21 June 2021

Application No: SSD-10822510

Re: Randwick City Council submission on the State Significant Development SSD-10822510 – UNSW Health Translation Hub (SSD-10822510)

SCH - Bridge Connection - Floor Plan

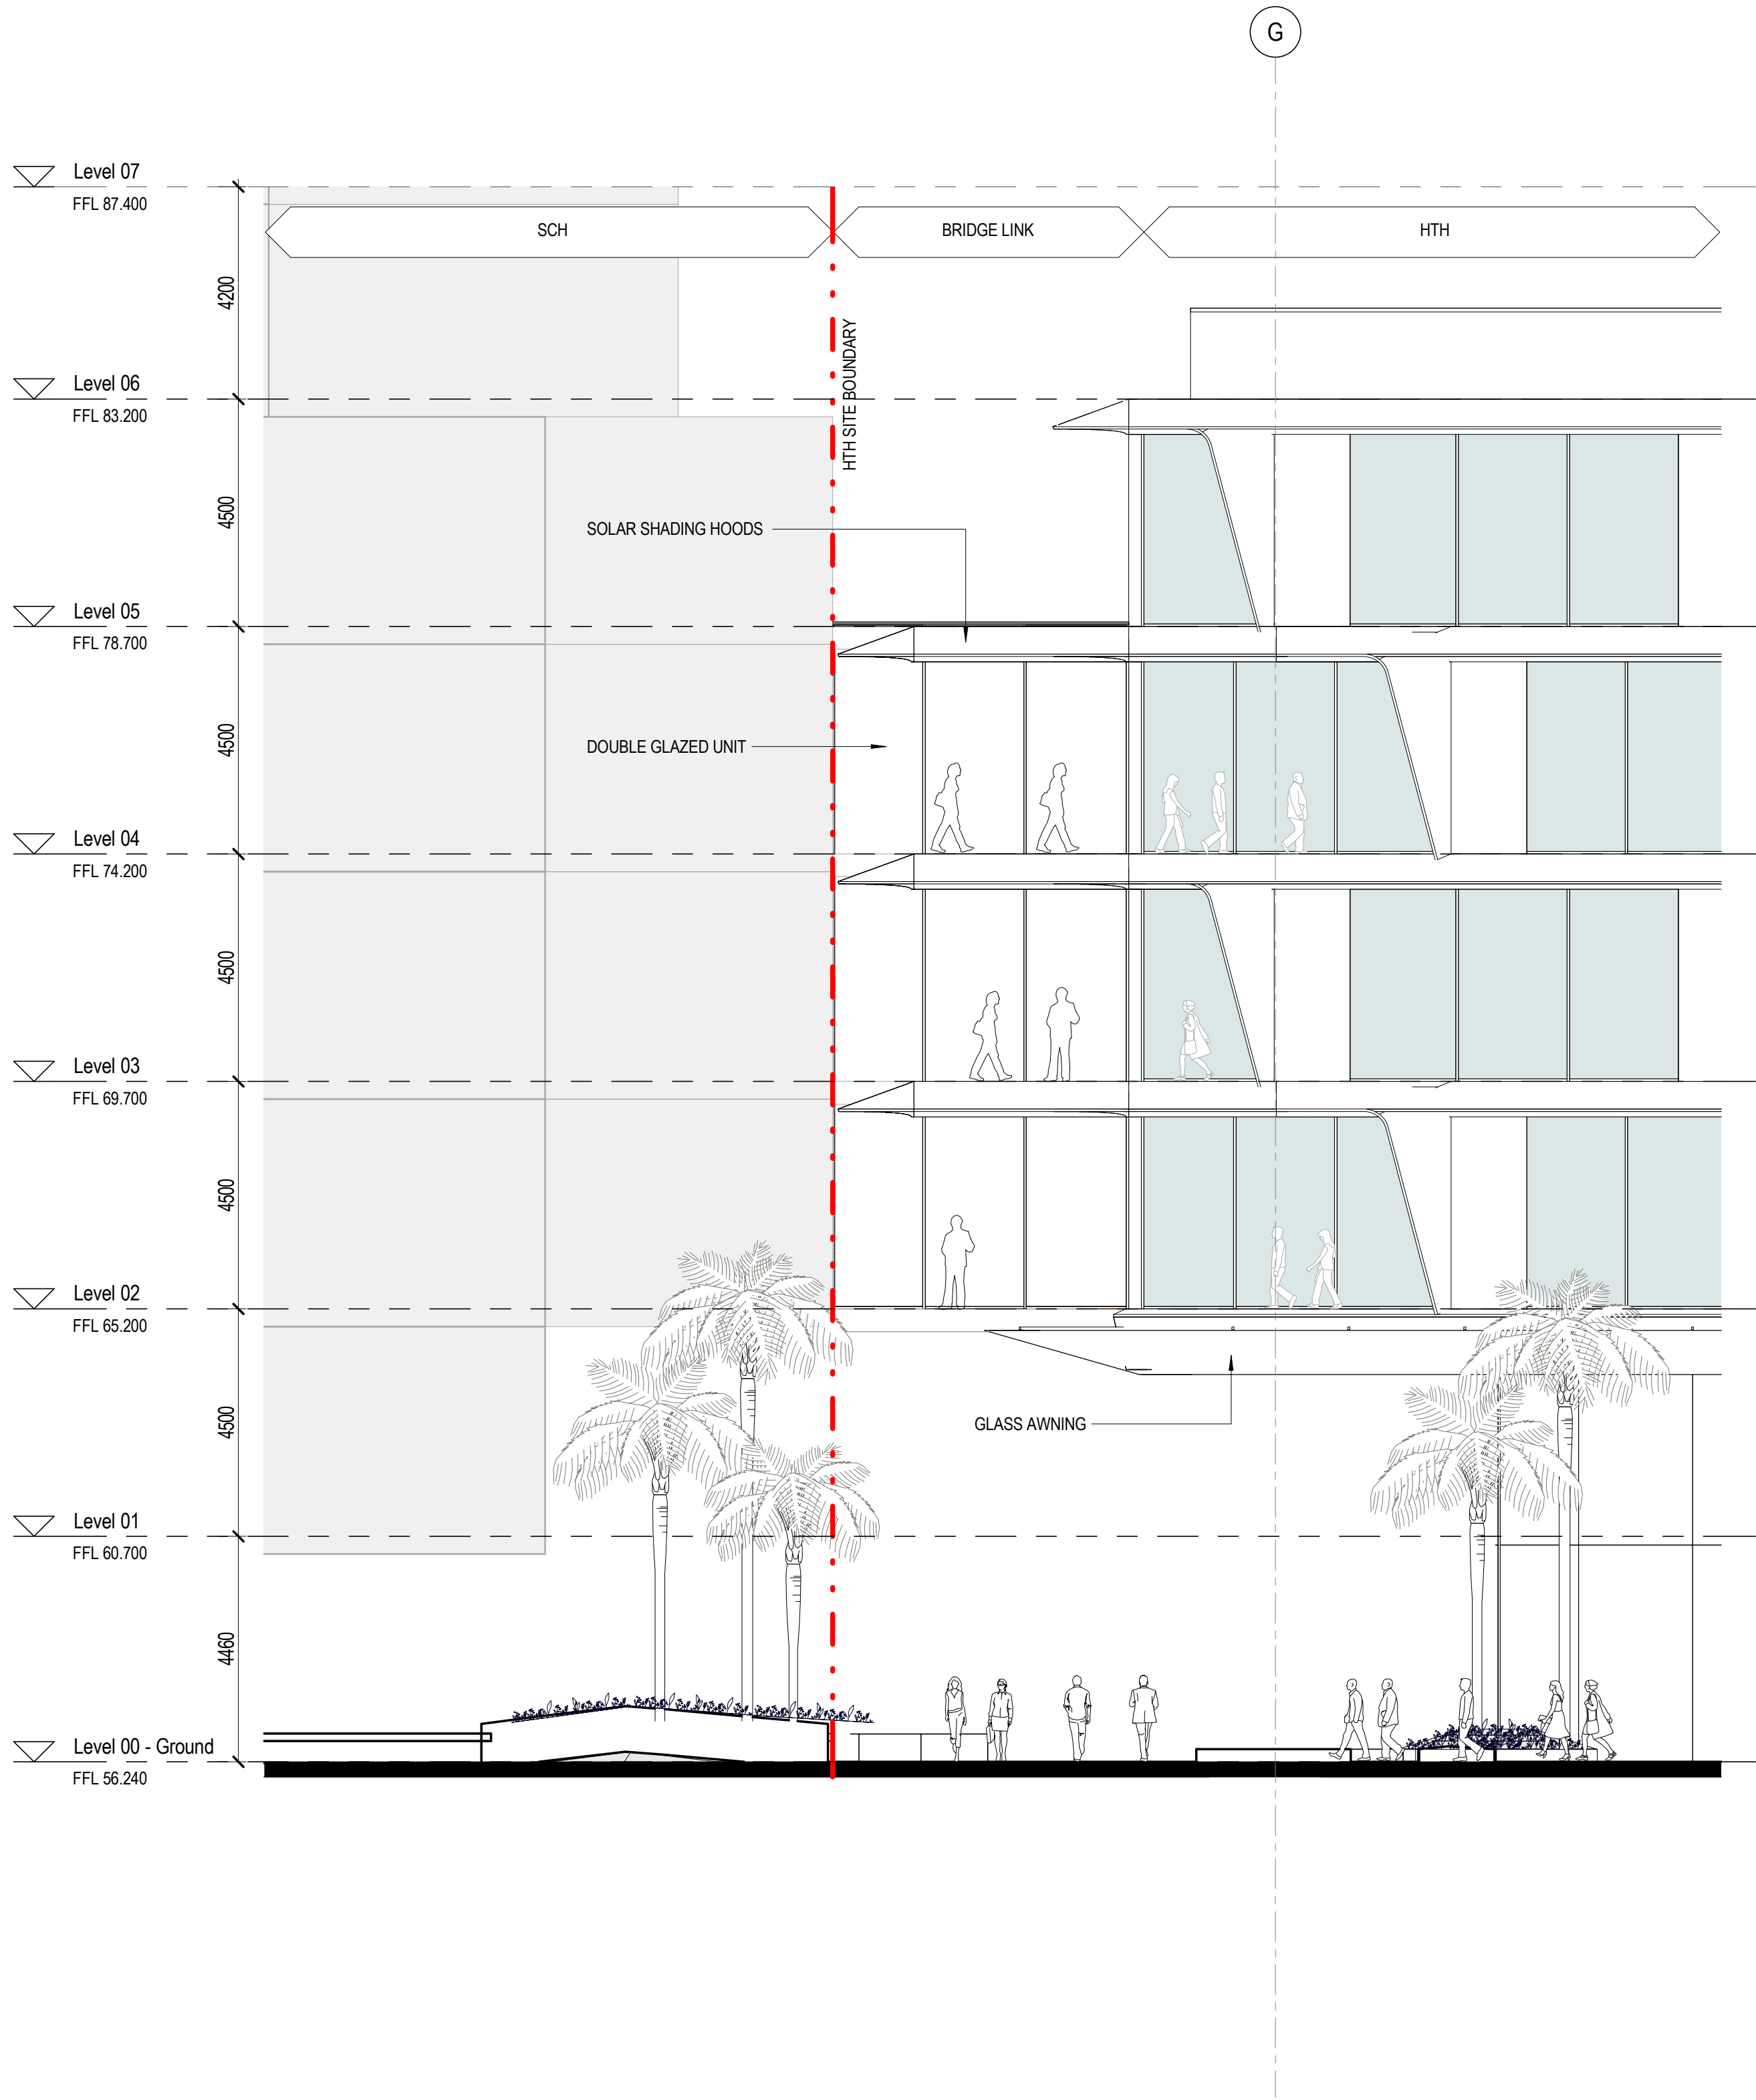
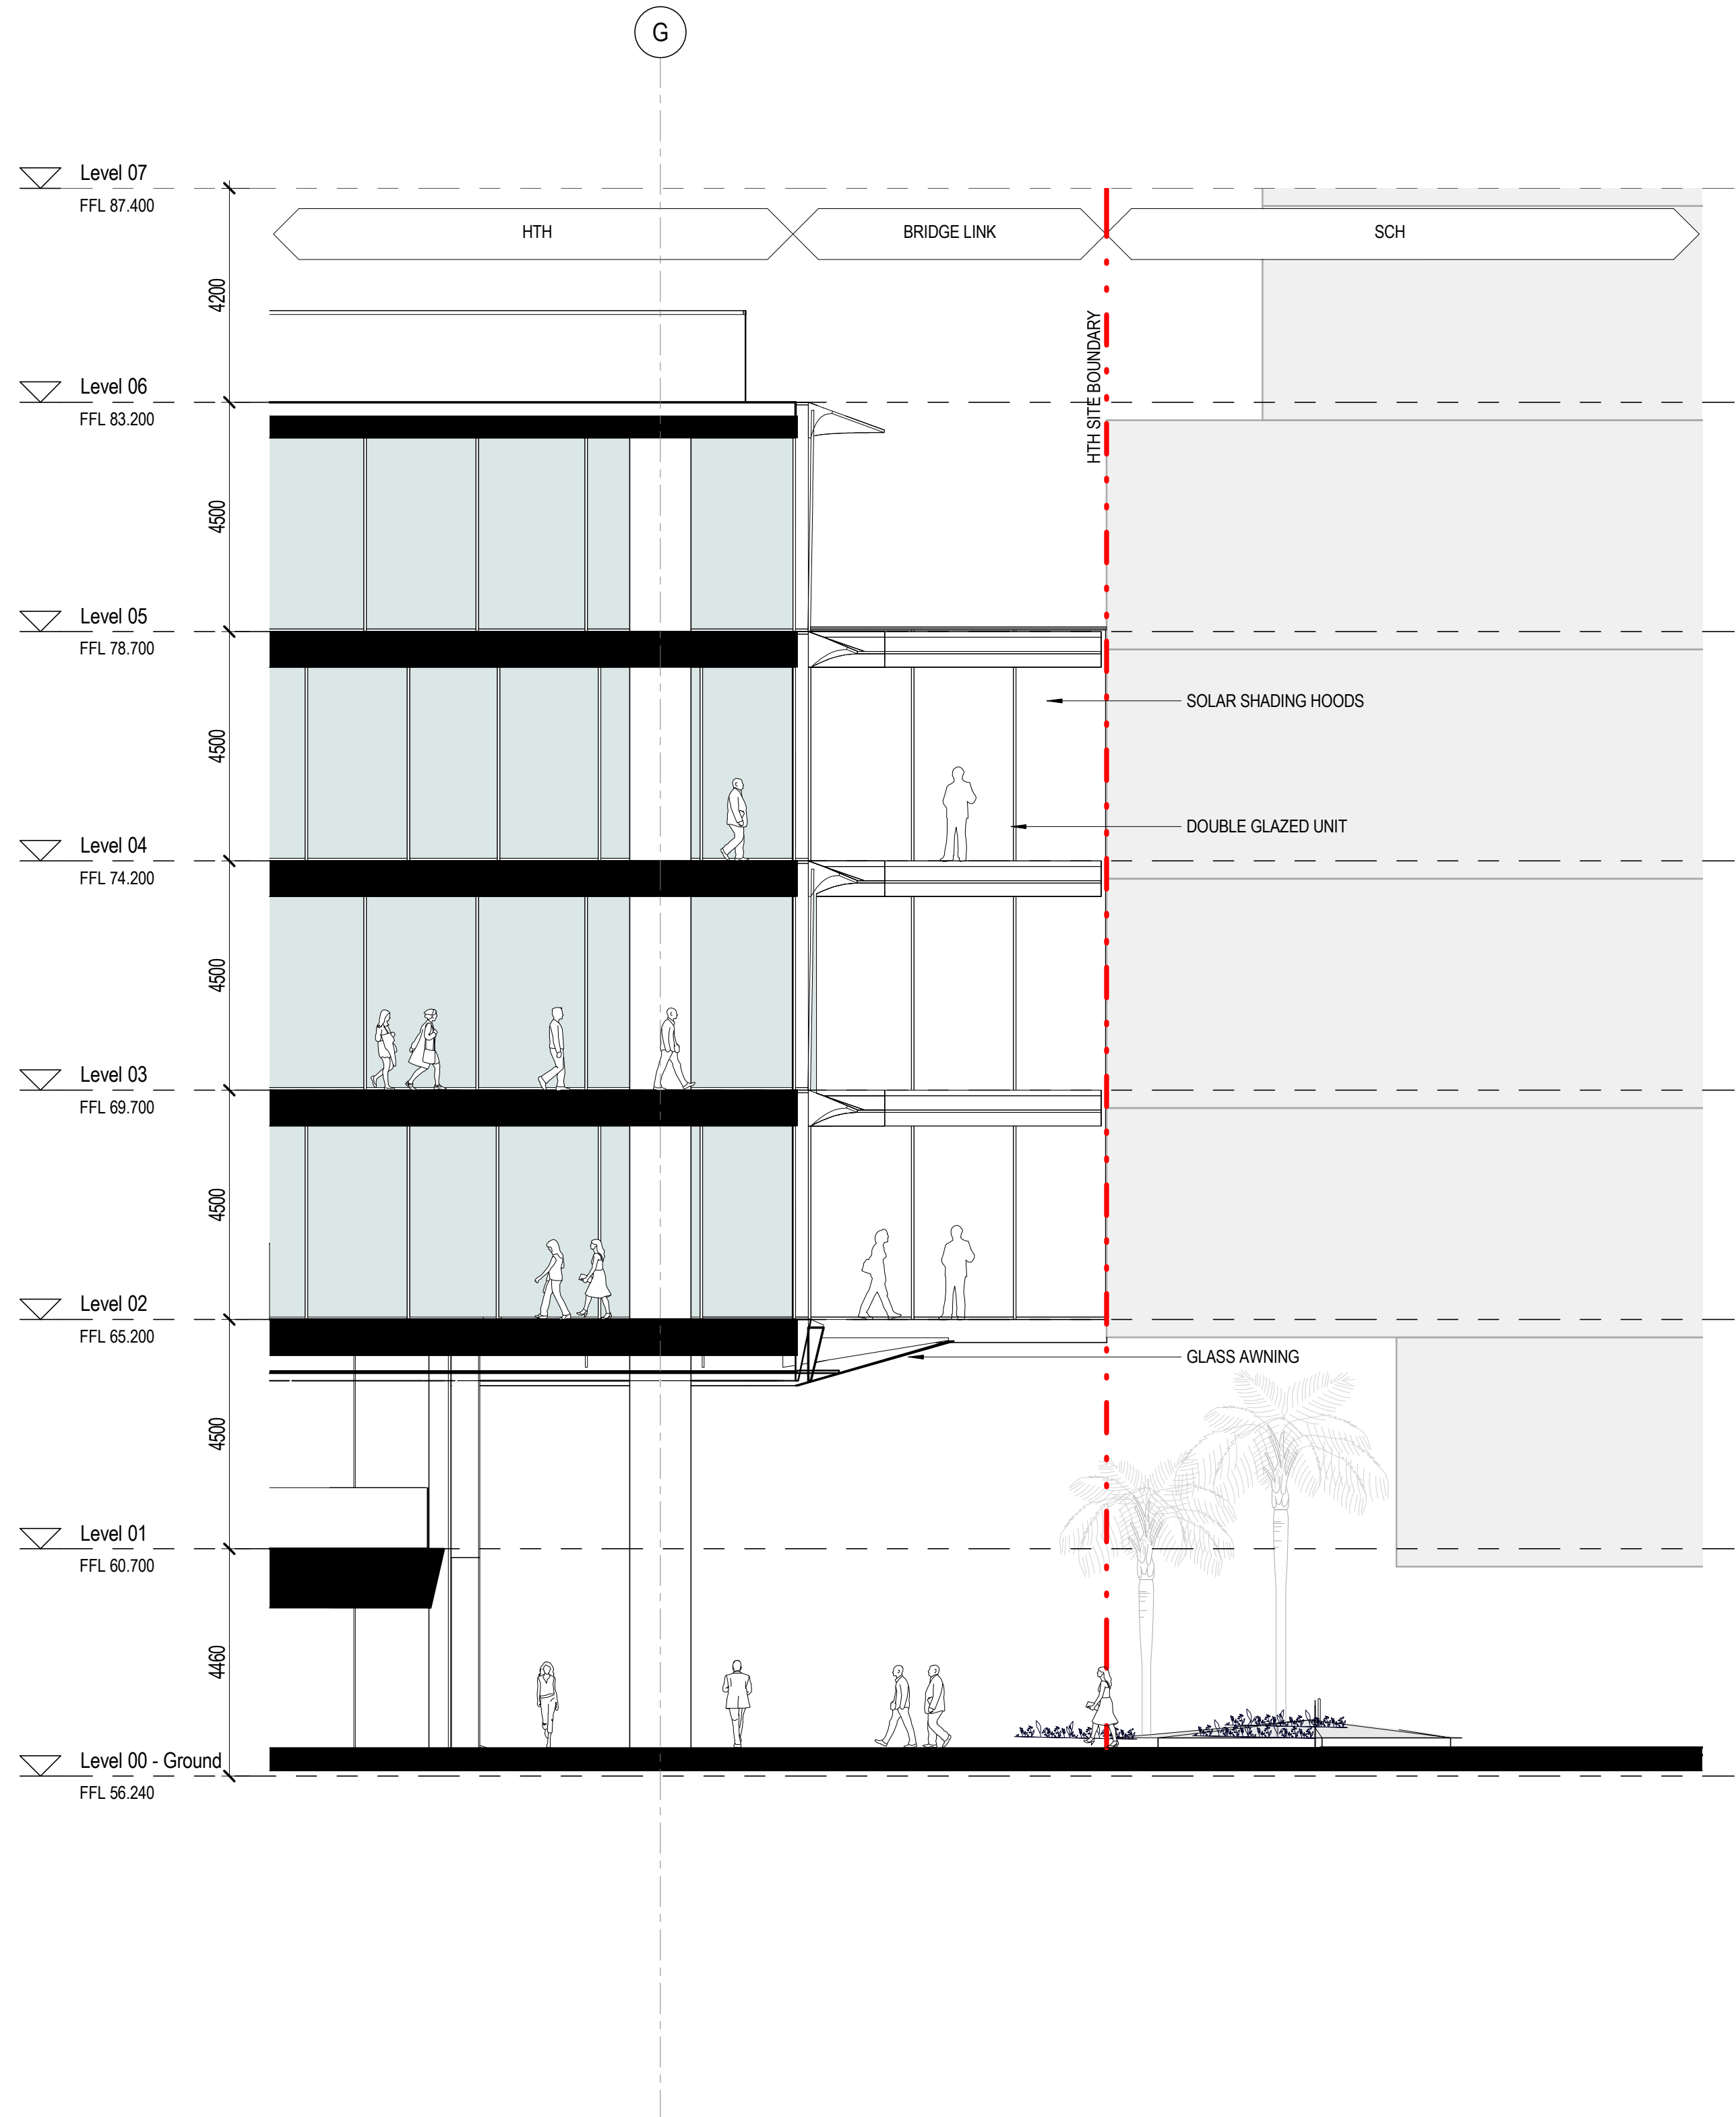
10. The location of the bridge and the visual openness and transparency of the bridge are supported. These elements should be retained and refined during the detailed design phase.
11. Council questions the reason for providing a central open-air section with glazed airlocks at each end of the bridge. A continuous glass enclosure may provide better weather protection for people crossing the bridge and remove the need for two airlocks.
12. Council requires further information with regard to the legal instrument proposed to locate this piece of infrastructure within the public road reserve.

Shadow Analysis

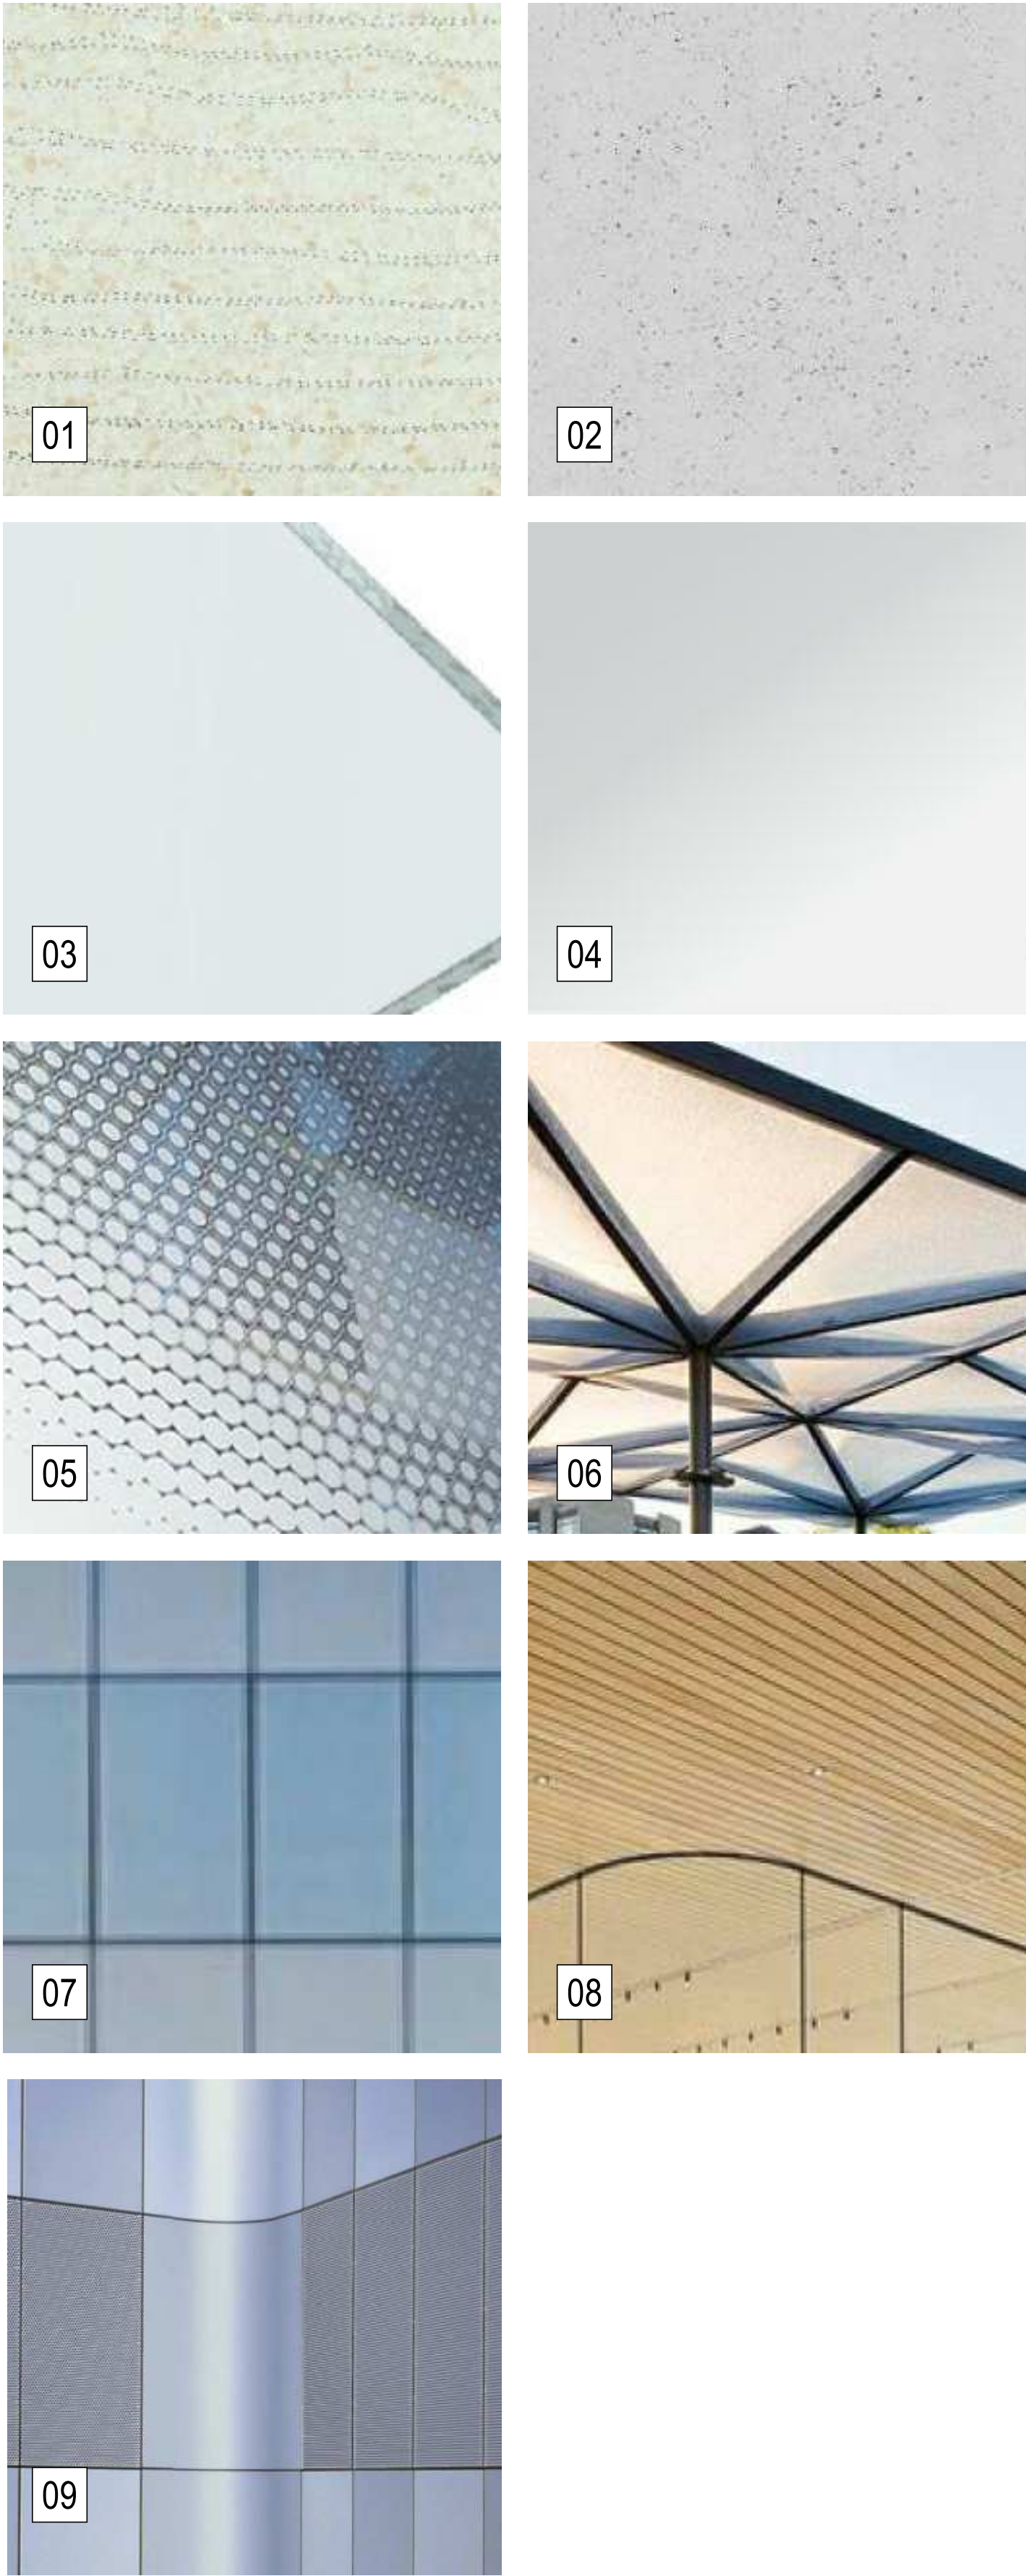
6. The Integrated Acute Services Building (IASB) forecourt and main hospital vehicular drop-off/pick-up has the potential to provide an important new green space along Botany Street for the enjoyment of Randwick Hospital, the UNSW campuses, and the broader Randwick community. It will be important to provide a quality landscaped experience that is not unduly overshadowed in the winter months by the upper levels of the proposed UNSW HTH building to the north.
7. It appears that the current southern leg of the UNSW HTH building will overshadow the Children's Hospital emergency vehicular drop off loop and pedestrian waiting area, as currently configured, for most of winter months.
8. The shadow diagrams provided are limited, addressing only the early morning, midday and late afternoon. Hourly shadow diagrams at the 21 June should be provided to assess solar access and amenity.
